Barratt/David Wilson Homes development – Replan Area – OS Parcels 6741 & 5426, West Cricket Field North, Bodicote – Plots 95-98 & 82-83 – Permission 21/03639/F, dated 28th November 2023 – site address now known as Whitechapel Gardens

**Housing Strategy and Development Team
Housing Services
Planning Application Comments**

Planning Application Number: 21/03639/F - Revision

Site Name: Os Parcels 6741 And 5426 West Cricket Field North, Wykham Lane, Bodicote

Drawing file: 066-HT-FP-Type50_SEMI_REV A.pdf

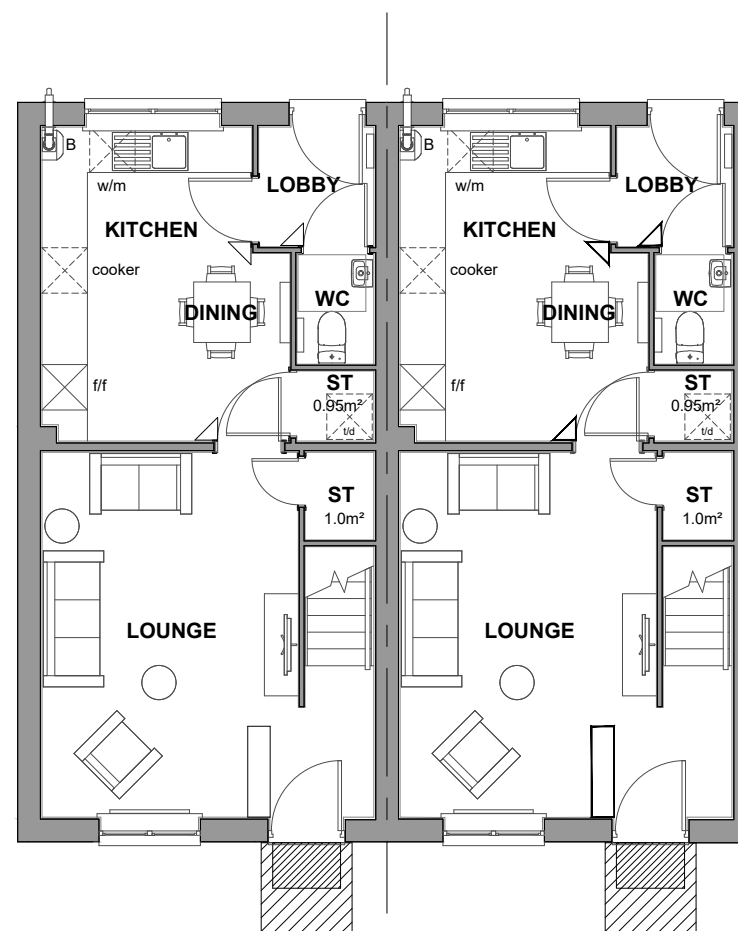
Plans submitted for approval by David Wilson Homes on 8th Feb.'22 – Plots 95-98 – BOD.HT.066 Rev A & BOD.HT.067 Rev A.

These revised plans were not referenced in the issued Decision Notice.

1. The dimensions for property type SH52 (plots 17, 18 & 19) to be amended to NDSS dimensions for 3-bed 5-person dwellings, ie a minimum GIA of 93m² or if possible, 3-bed 6-person dwellings with a minimum GIA of 102m² or a mix of both.
2. The plans for property type T50 (plots 95, 96, 97, 98) to be amended to NDSS dimensions for 2-bed 4-person dwellings ie a minimum GIA of 79m².
3. 50% of all rented dwellings to meet the requirements of M4(2) Category 2: Accessible and Adaptable dwellings. We would request that plans are submitted showing the dimensions and features which will constitute compliance with these standards.

Despite David Wilson Homes' agreement to revise their plans for the dwellings on Plots 95-98 and 82-83, the Decision Notice erroneously referenced the unmodified house designs to these plots and Barratt Homes have built to the plans approved under the Decision Notice.

The revised plans show that type T50 dwellings have now been amended to 81.4m² which complies with NDSS.
